CITY OF PORTLAND

BUILDING PERMIT

Job ID: 2012-09-5020-ALTR

has permission for Removal of exist stairs; rebuild new two (2) level deck (Two Family Residence).
provided that the person or persons, firm or corporation accepting this permit shall comply with all of the provisions of the Statues of Maine and of the Ordinances of the City of Portland regulating the construction, maintenance and use of the buildings and structures, and of the application on file in the department.

Date Issued: Sept. 20, 2012
 Project Number: 121001
 Drawing Scale: _____
 SHEET NAME: FLOOR PLAN / ELEVATION / DETAILS
 Drawn By: MC
 Checked By: MC
A-1.0

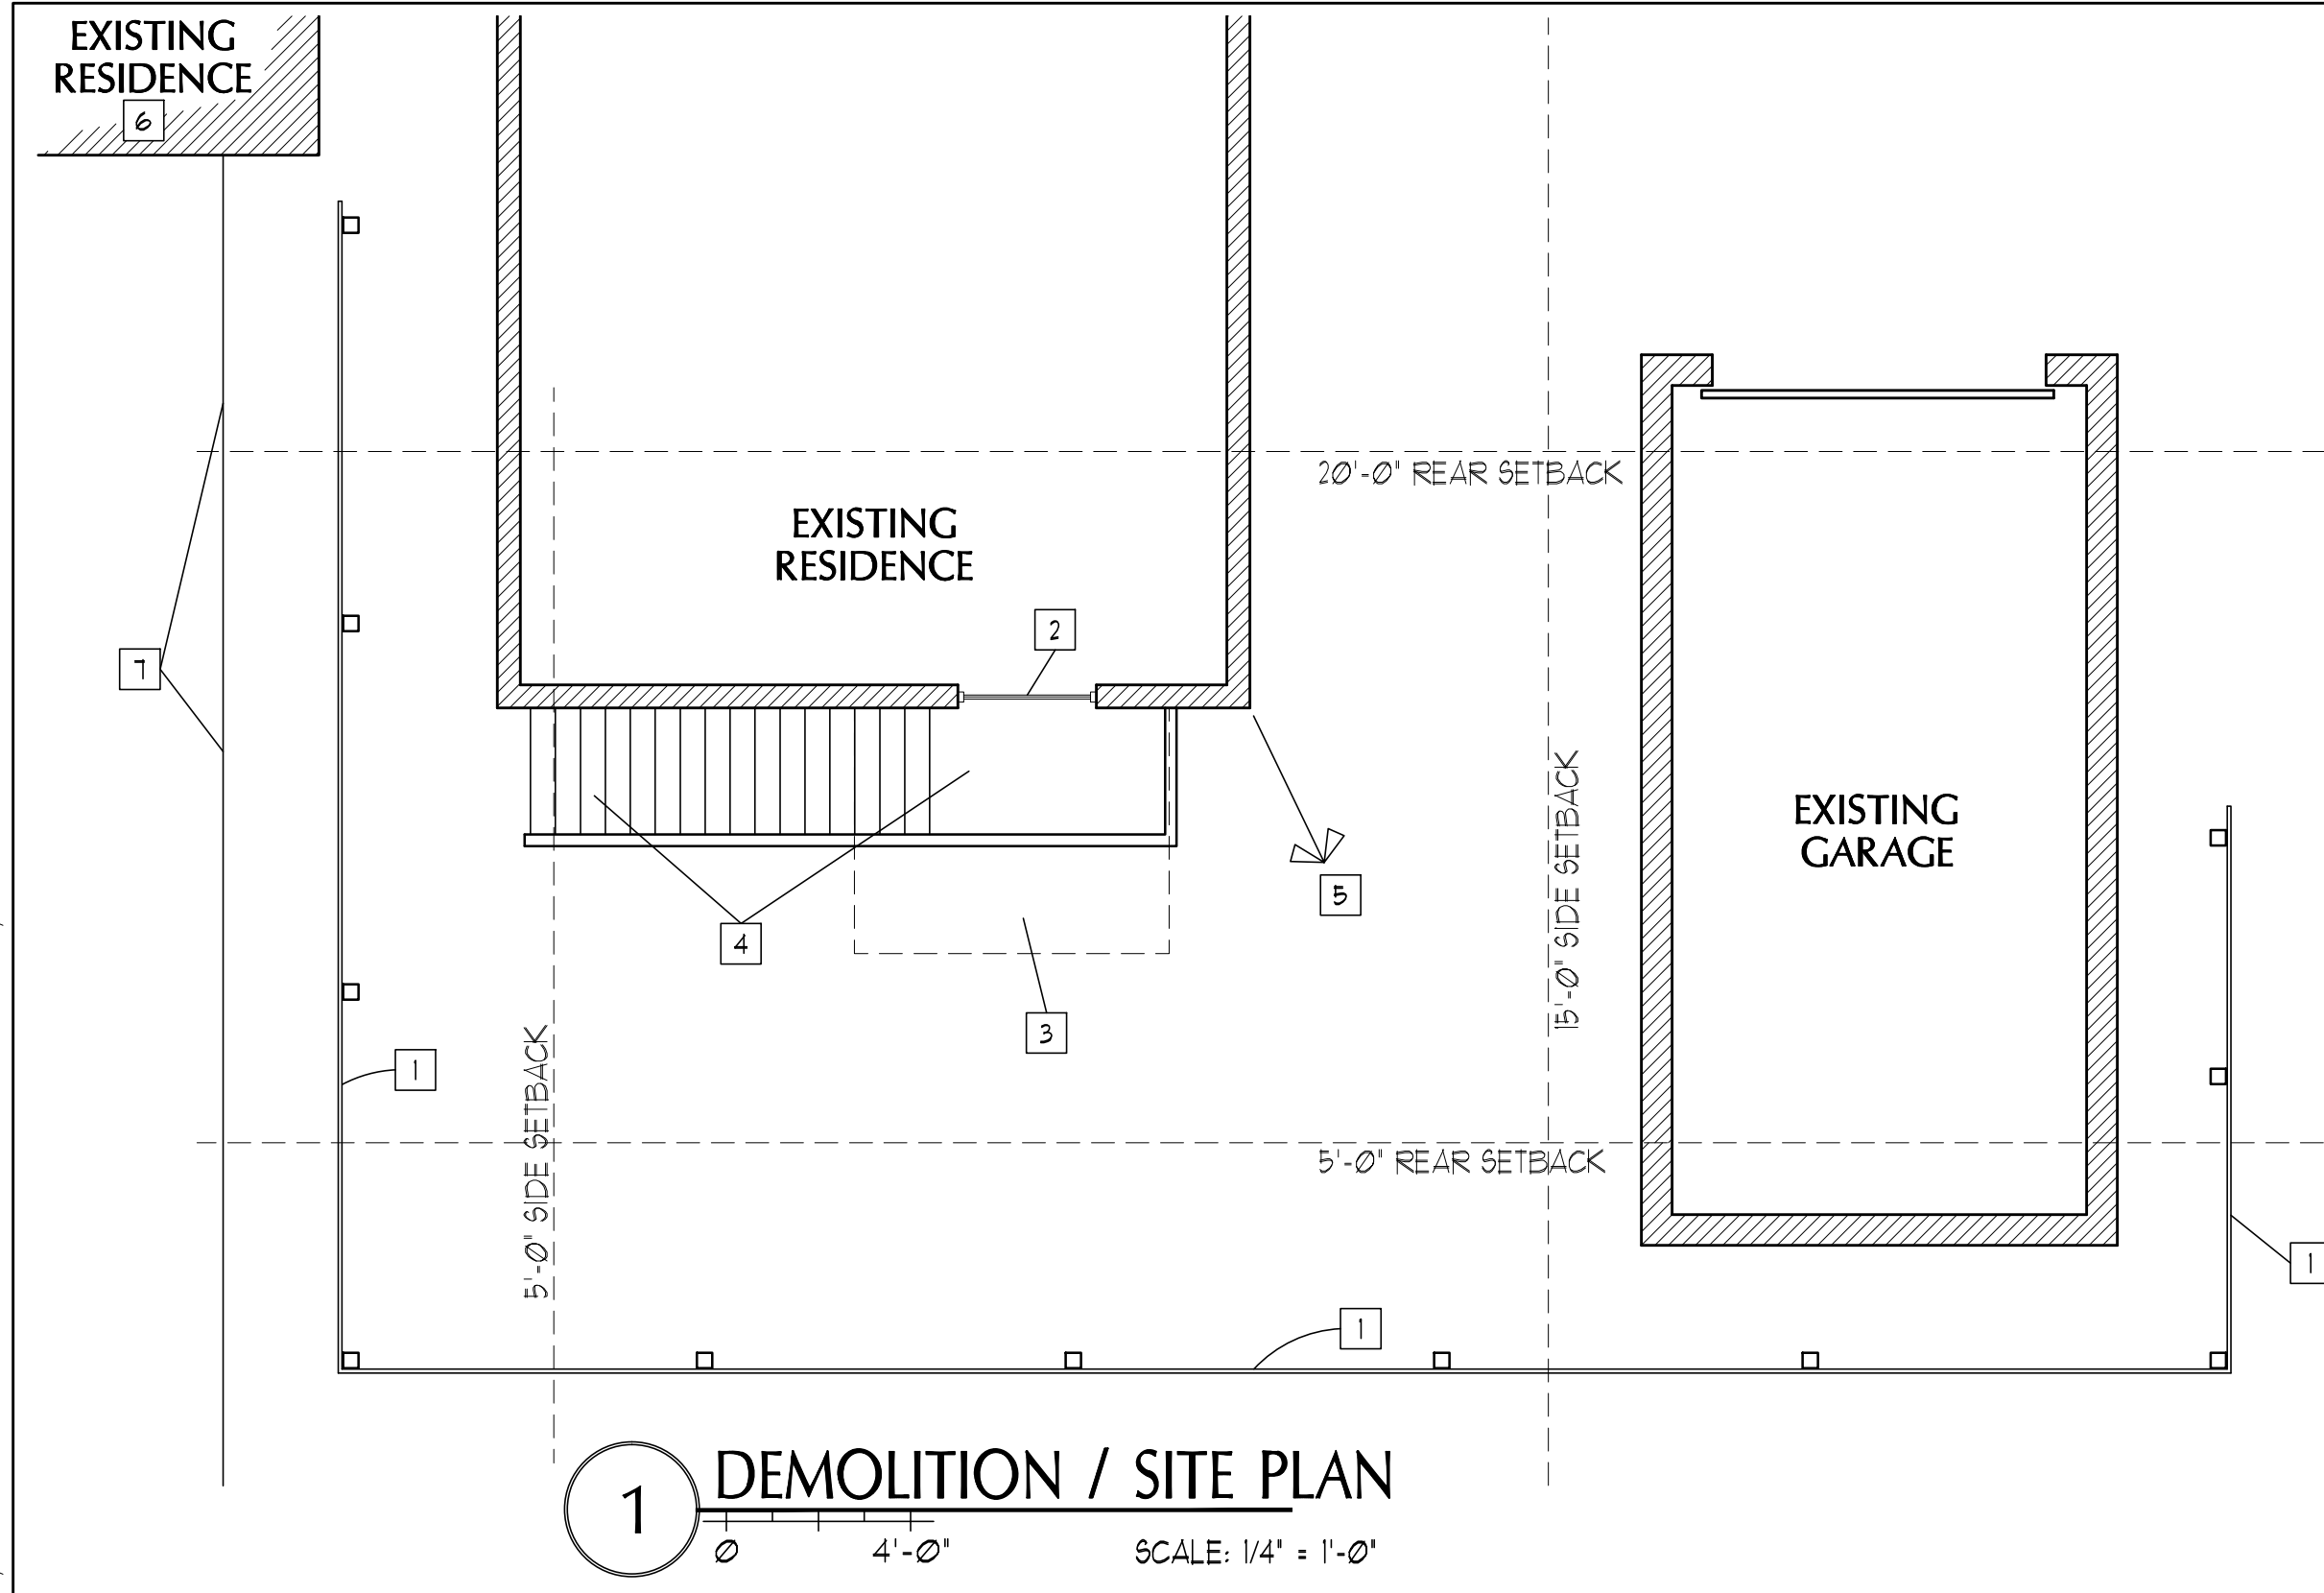
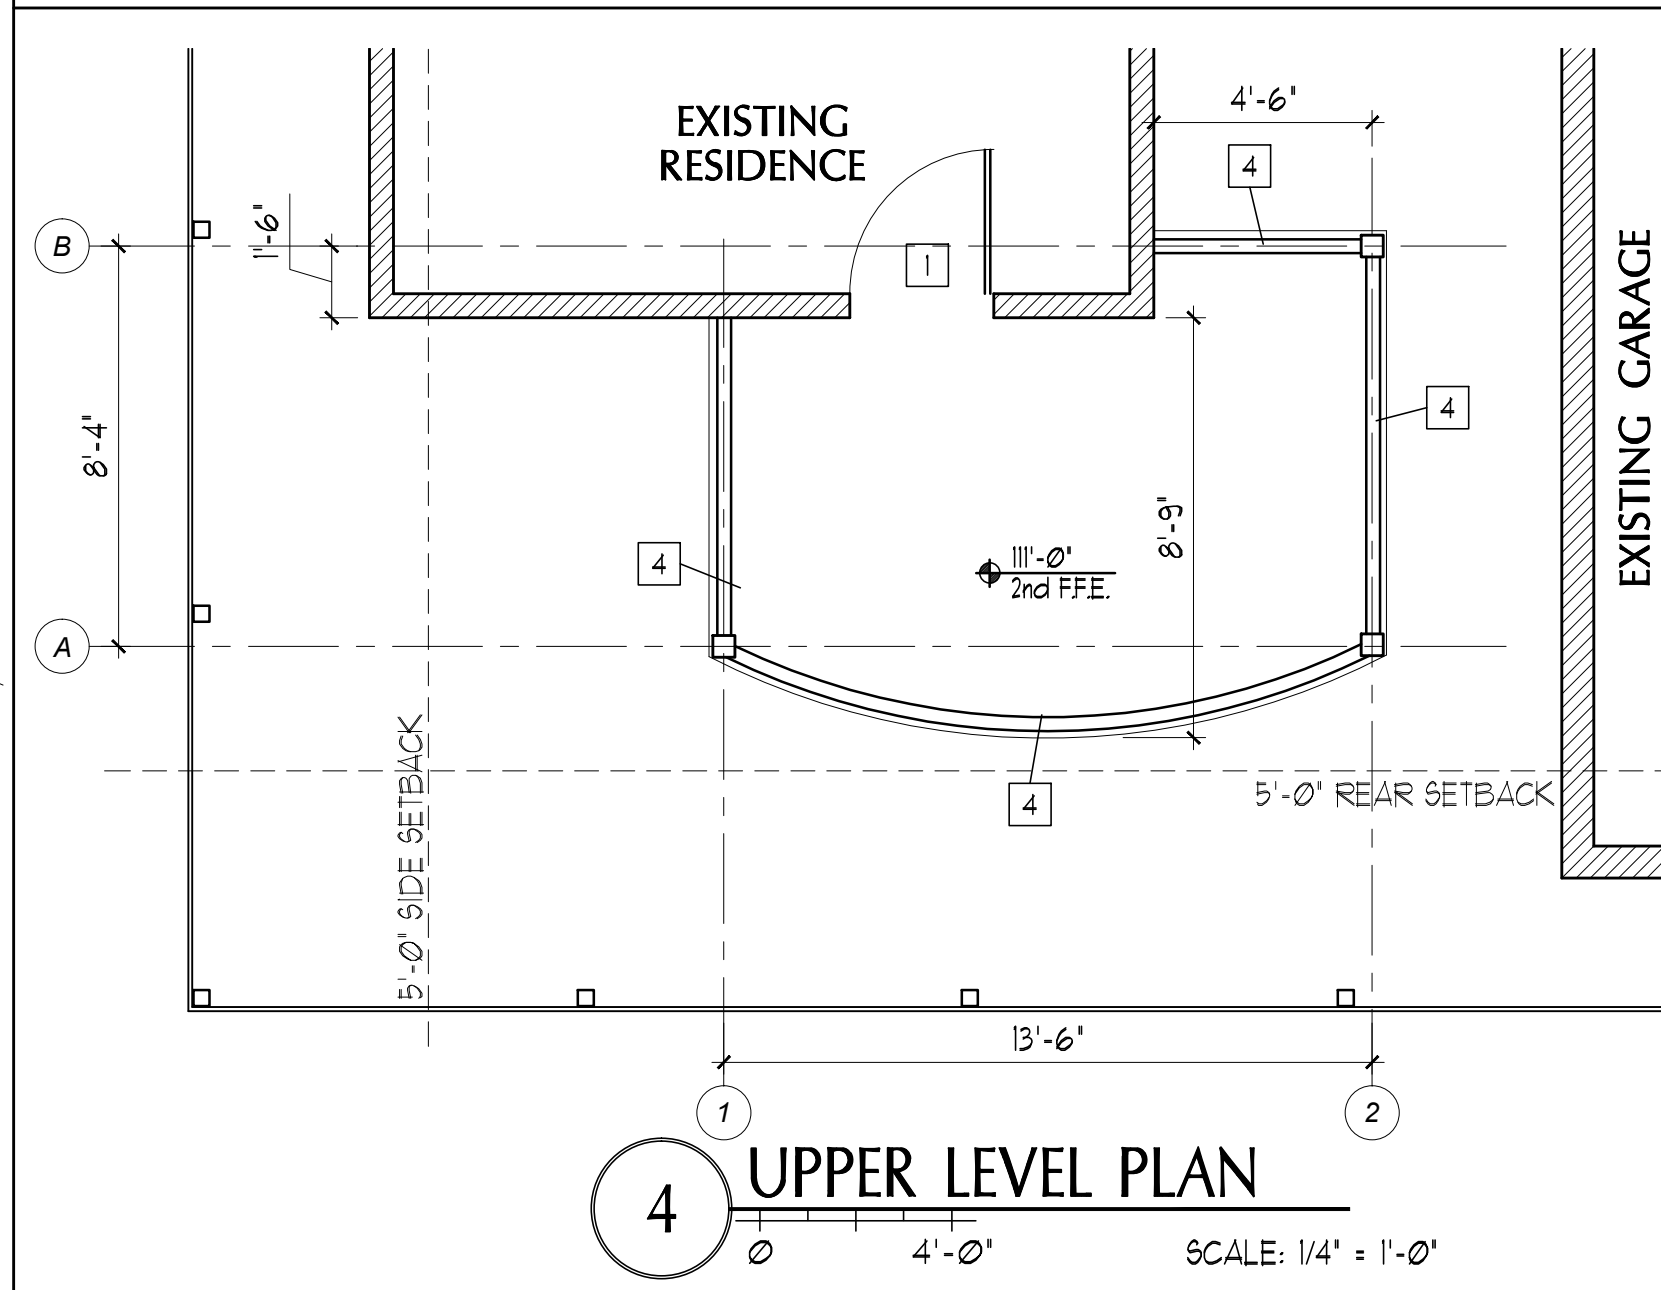
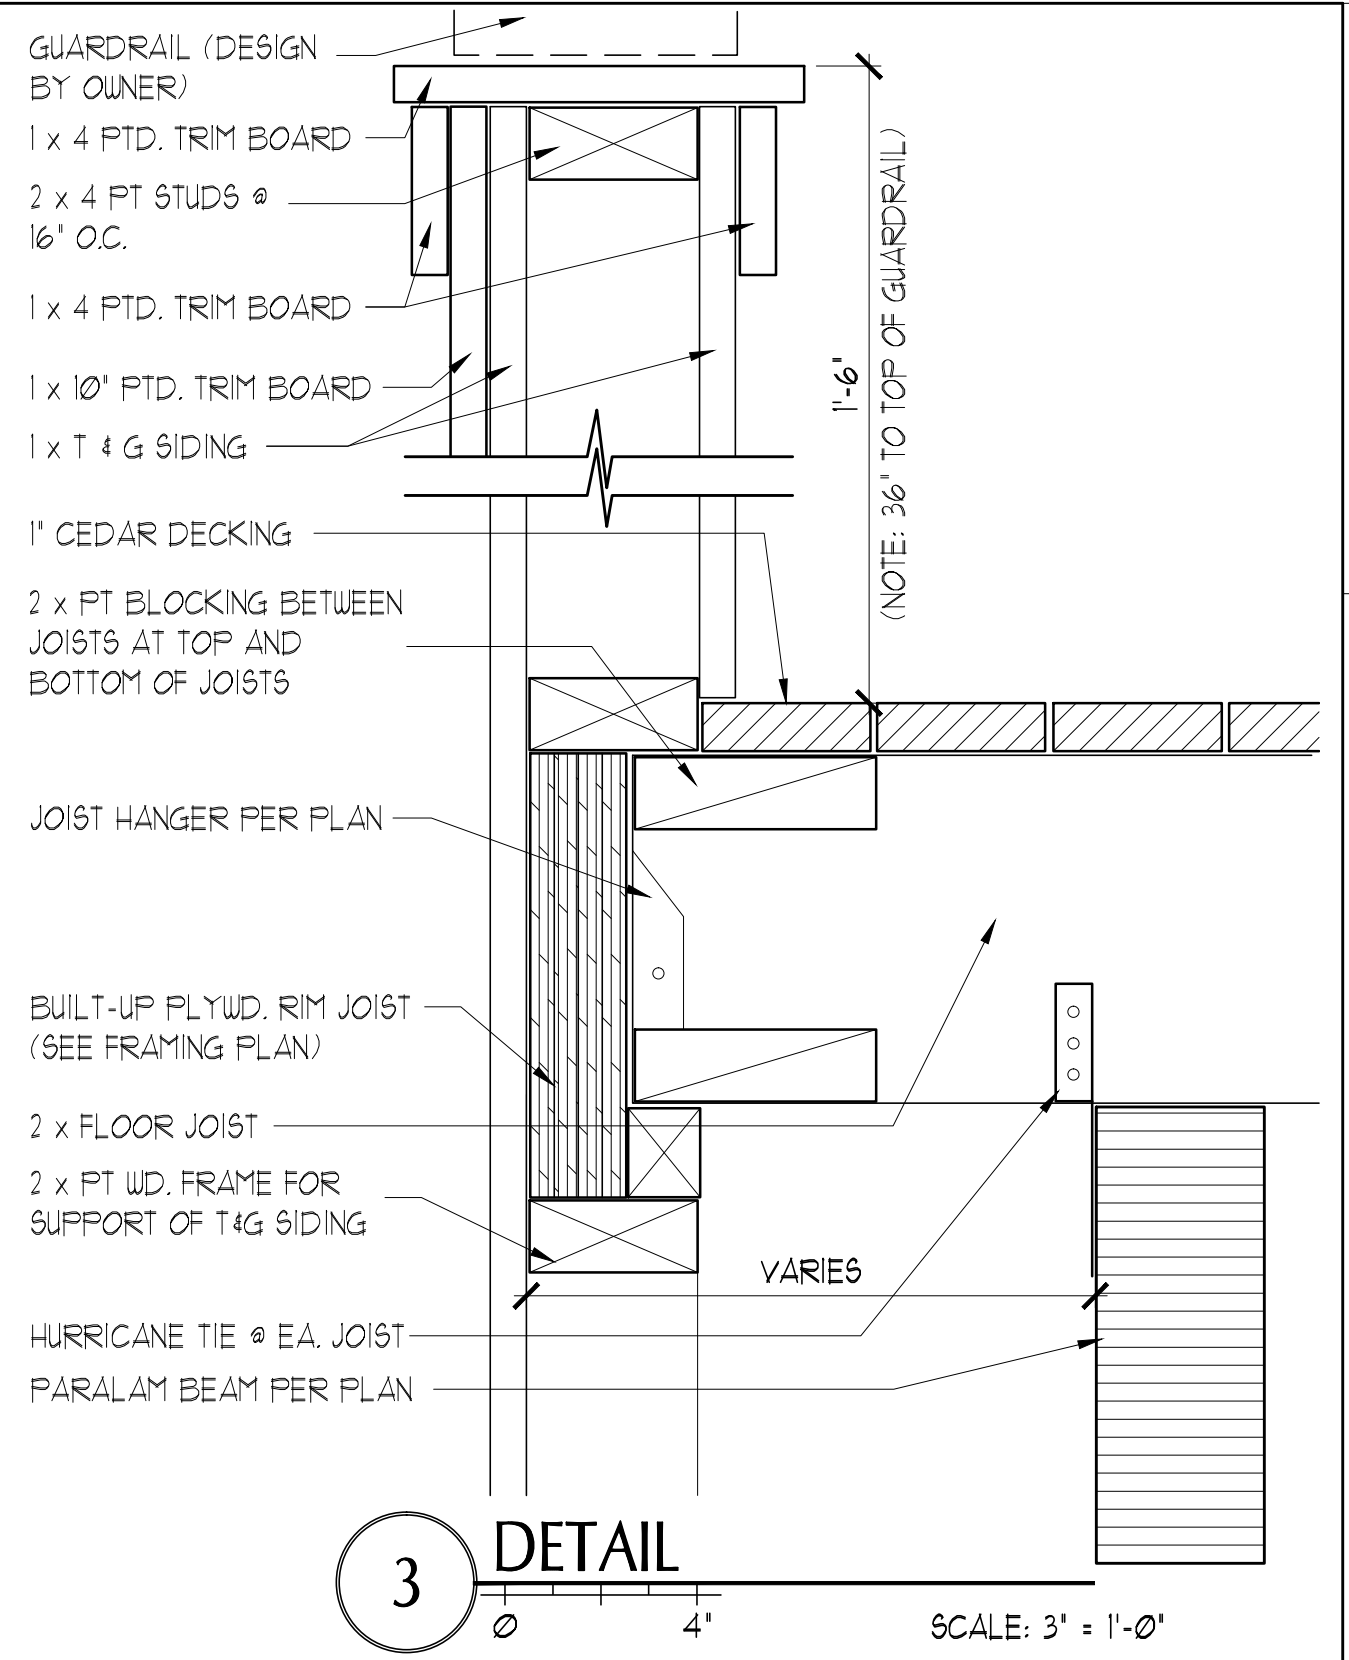
- a. Note: Architect stated that both units have independent means of egress.
3. A graspable handrail (34-38 inches in height) shall be provided on at least one side of each continuous run of treads or flight with four or more risers. Fall protection (36 inches) from exterior decks may be required if floor joist are at or above thirty (30) inches from grade.

4. R312.3 Opening limitations. Required guards shall not have openings from the walking surface to the required guard height which allow passage of a sphere 4 inches in diameter.

6. R311.5.1 Attachment. Exterior landings, decks, balconies, stairs and similar facilities shall be positively anchored to the primary structure to resist both vertical and lateral forces or shall be designed to be self-supporting. Attachment shall not be accomplished by use of toenails or nails subject to withdrawal.

1. The square footage is measured to the edge of the deck - the dimensions on the plan seem to go to the middle of the columns. This is important because you are saying the footprint is 170 sf which gives you exactly 50% lot coverage. You also need to include the footprint of any landing and stairs that are not shown on the assessor's footprint.
2. For the square footage of the deck, did you figure in the footprint of the stairs from the lower level?
3. Besides the 50% lot coverage, you also need to show that there is 20% open space. Open space is the area that is not covered by impervious surfaces (footprint of structures & any pavement).

As we last left off, we were ascertaining the maximum size of the deck that would be possible. However, we did run into the issue of 50% building coverage. When we talked last, you explained that any entry steps would be included in the building coverage numbers as well as impervious surface. Upon measuring the steps into the residence, it was determined that the deck needed to be reduced by quite a bit. This required analysis by the owner to determine if they still wanted to go through with the project as they would lose a section of the deck. If you remember, there was an intermediate level to the deck. This area would have to be eliminated.

Area left for new deck: $3040 \text{ sf} \times 50\% = 1,520 \text{ sf} - 1,395.8 = 124.2 \text{ sf}$ (Therefore, we made the new deck to be 124 sf). See attached (we had to adjust it the size to make it slightly smaller).

Impervious surface: $(1,141 + 209 + 40.8 + 5 + 124 + 607 + 16 + 33.4) = 2,176.2 \text{ sf}$ (...with 255.8 sf left to spare).
